**RE: SYDNEY METRO VICTORIA CROSS OVER STATION DEVELOPMENT –
RESPONSE TO SUBMISSIONS**

I refer to Council's letter dated 28 November 2019 outlining Council's objections to the two Victoria Cross over station development applications. The first being the Section 4.55(2) application to modify the SSD consent (SSD17 8874) (Council ref: DA.349/19/2) and the second being the development application for the over station development by Lend Lease (SSD 10294) (Council ref: DA.350/19).

DRG No. SMCSWSVO-LLC-SVC-AT-DWG-420000 1.0 EDMS No.

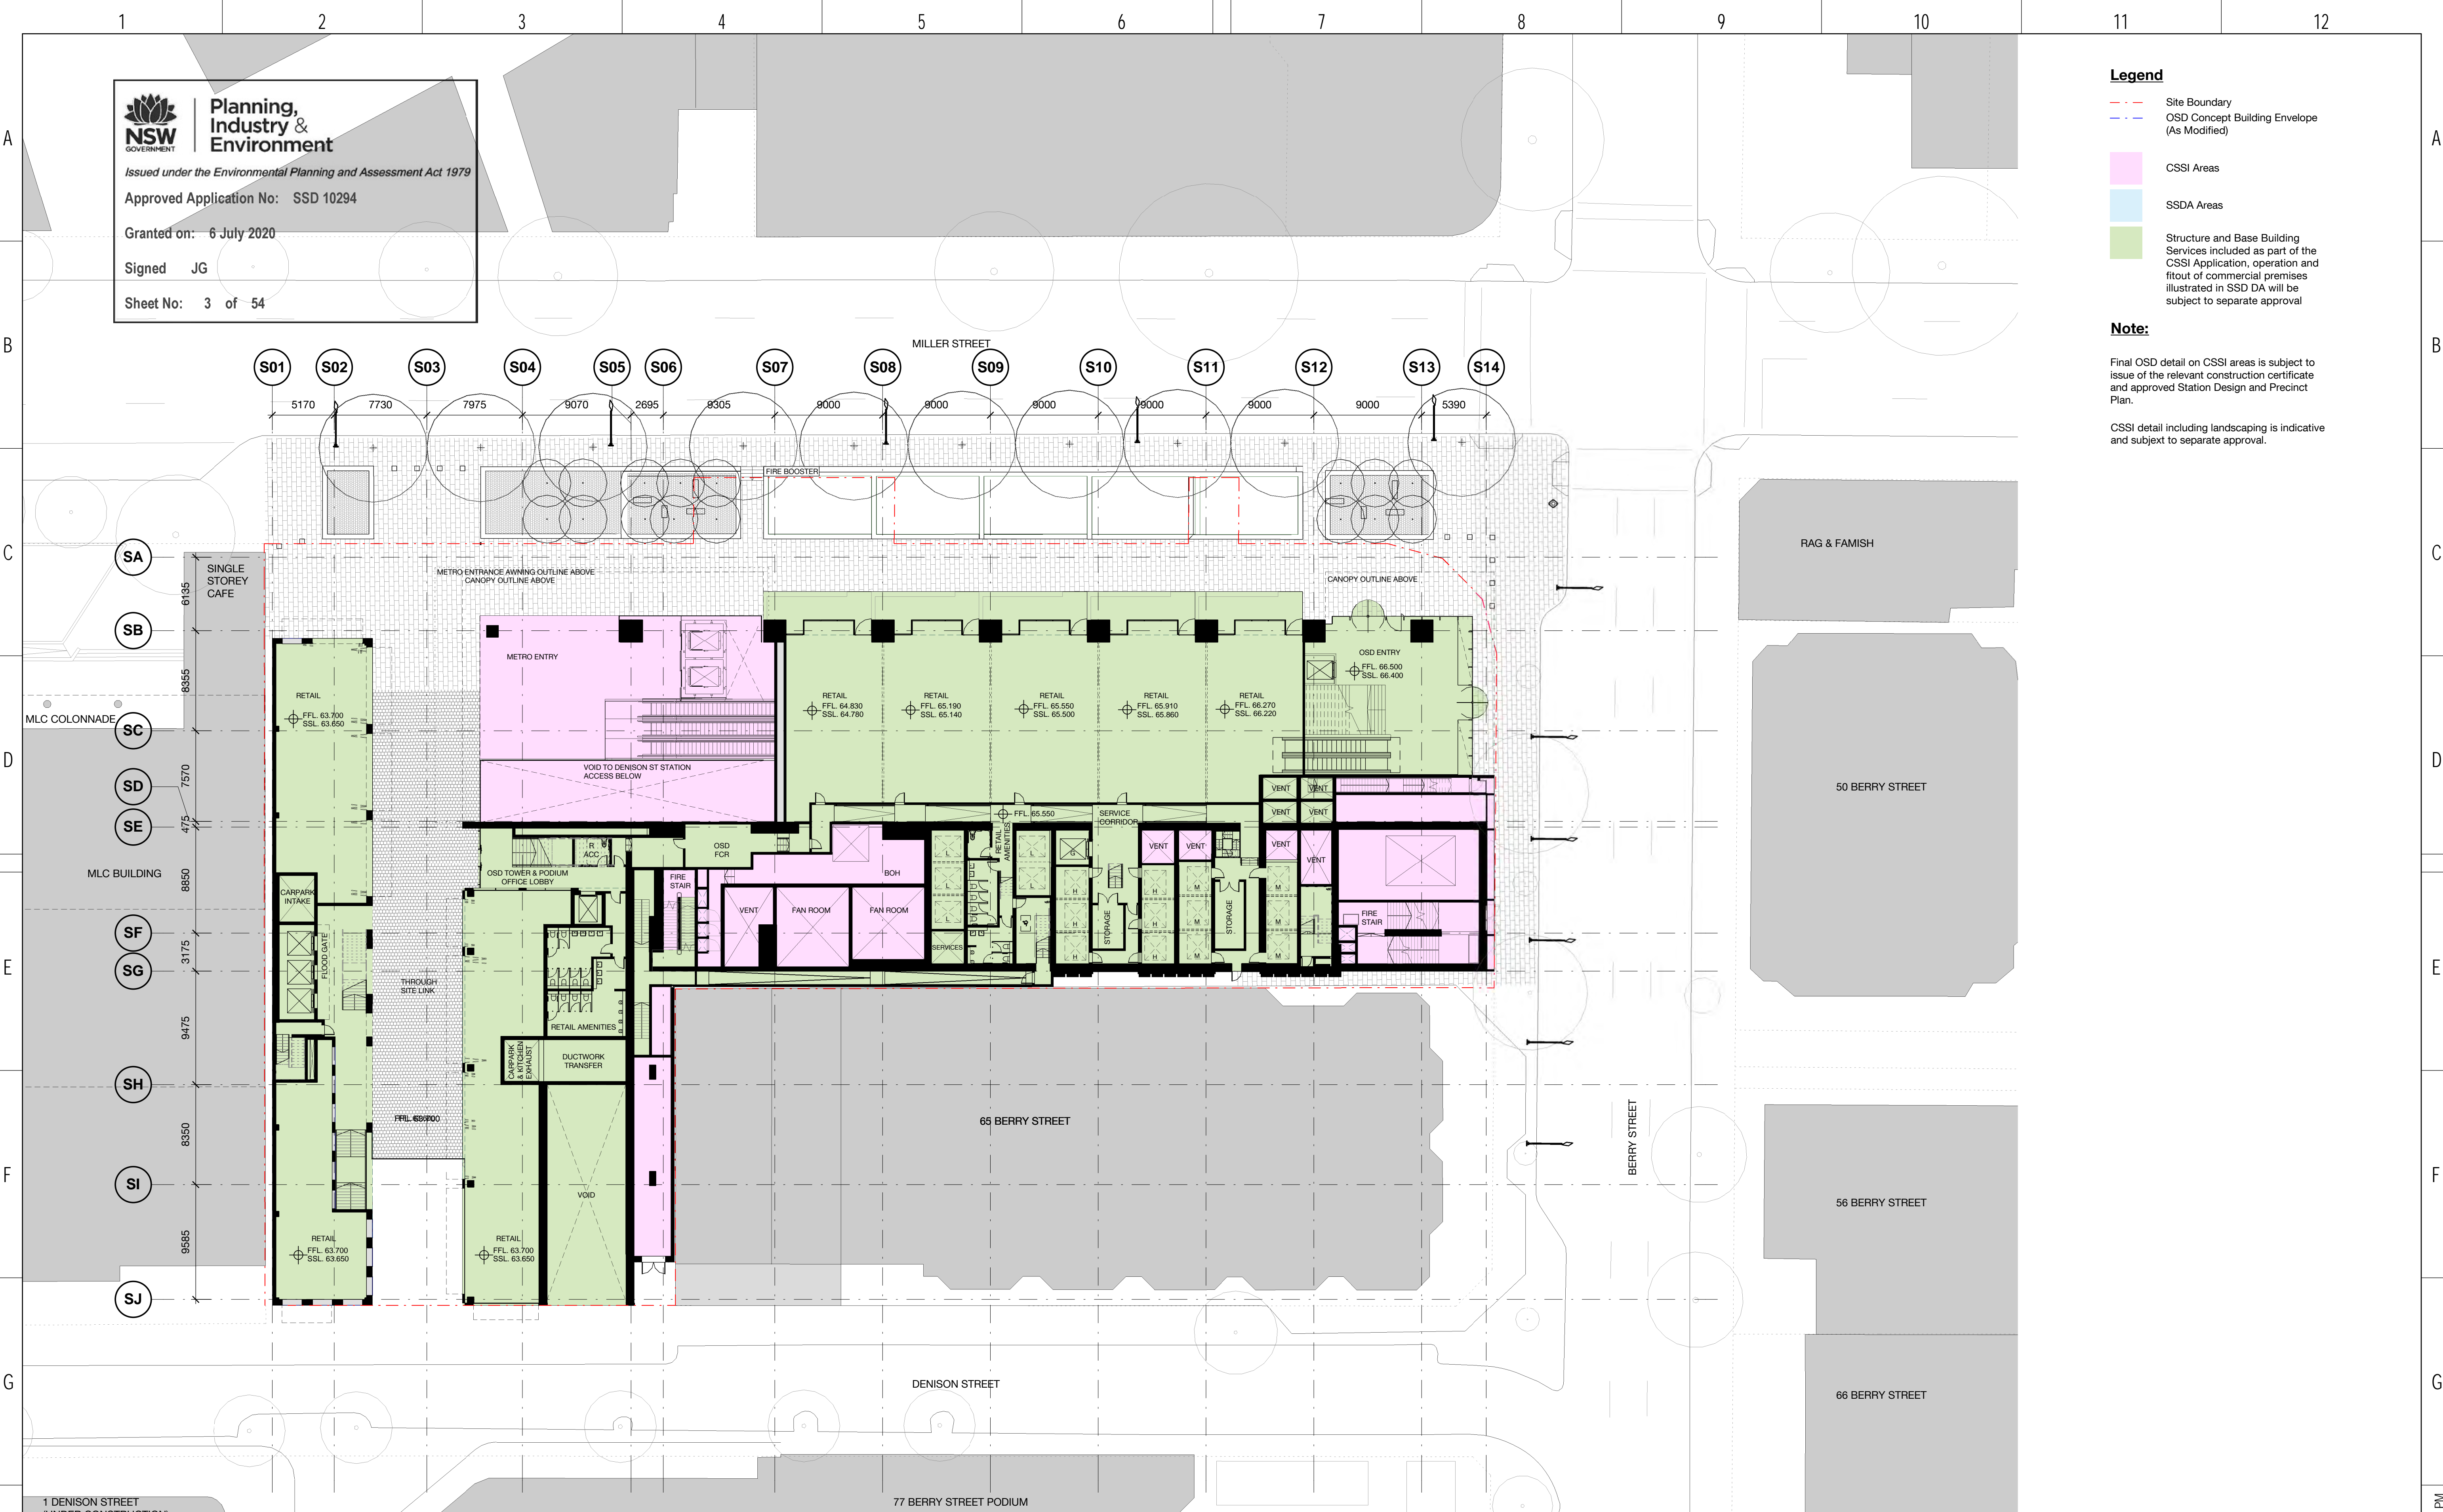
Council also believes that there is an opportunity to ensure a safe connection from the Metro through the MLC site and then the existing Greenway connection to North Sydney Station.

The short link through a proposed retail space could remain in place until the MLC site is redeveloped. The applicant could create a stratum lot over a section of the south western corner retail space and up to the southern boundary shown on Drawing numbered 420000.10 — Denison Street plan, dated 22 July 2019, drawn by Bates Smart, granting a right of way for pedestrians to provide a link to the Metro entry from the adjacent site known as 105 Miller Street.

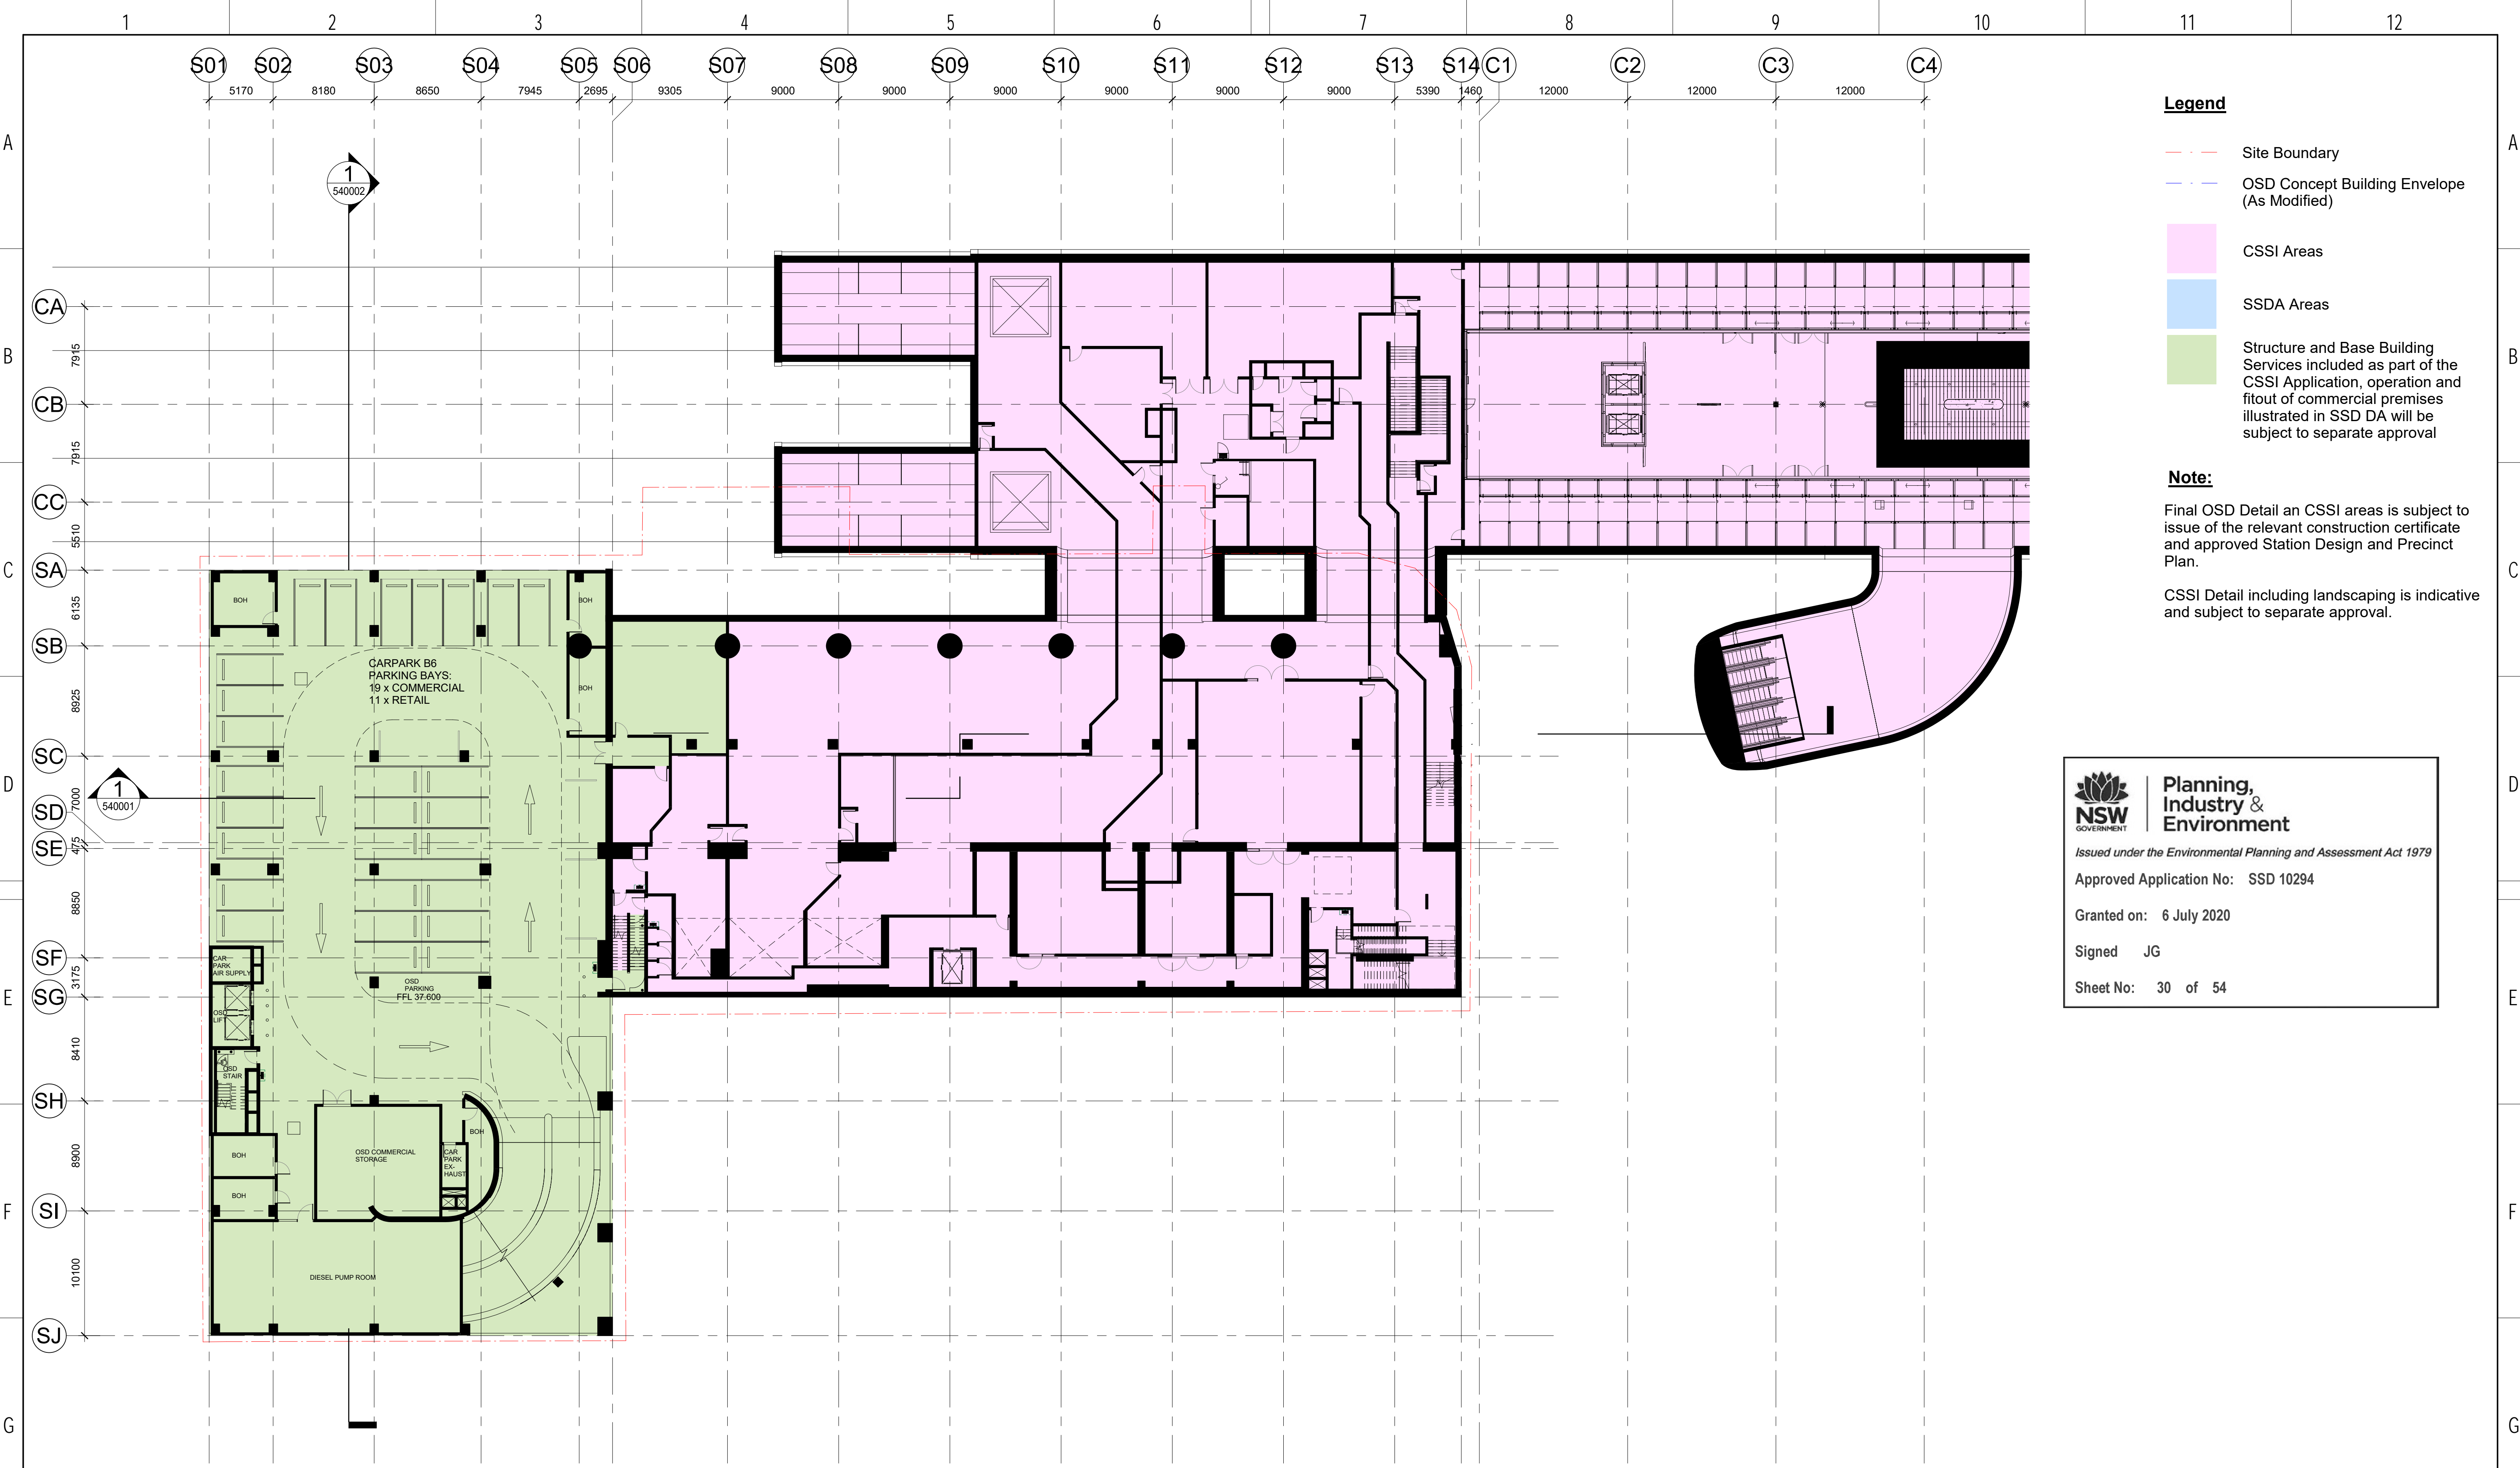
The development does not adequately safeguard a potential future underground connection south into the MLC Building to enable future consolidation of vehicular entrances to loading zones and facilitate safe pedestrianisation of Denison Street. A complete redevelopment of the MLC site may not occur in the short term, however alterations and additions to the MLC building could be possible in the near future.

A stratum lot or right of way could be created over the vehicle access from Denison Street to the link in level B1 to the boundary. The right of way over this section and could be subject requirements that the owner of the adjacent site be responsible for all costs to allow connection including fire doors and safety and contributions for on-going maintenance of the stratum lot. It is in the interests of the Metro and the OSD and a successful public domain in North Sydney for access to be made available.

G12. The applicant shall create a stratum lot or other appropriate easement or agreement over the Denison Street vehicle entry/exit along the vehicular ramp and up to the southern boundary on level B1 designated "safeguarded link" on Drawing numbered 521006.07 – B1 plant level, dated 6 August 2019, drawn by Bates Smart, granting a right of way for vehicles to enter and exit the adjacent site known as 105 Miller Street.
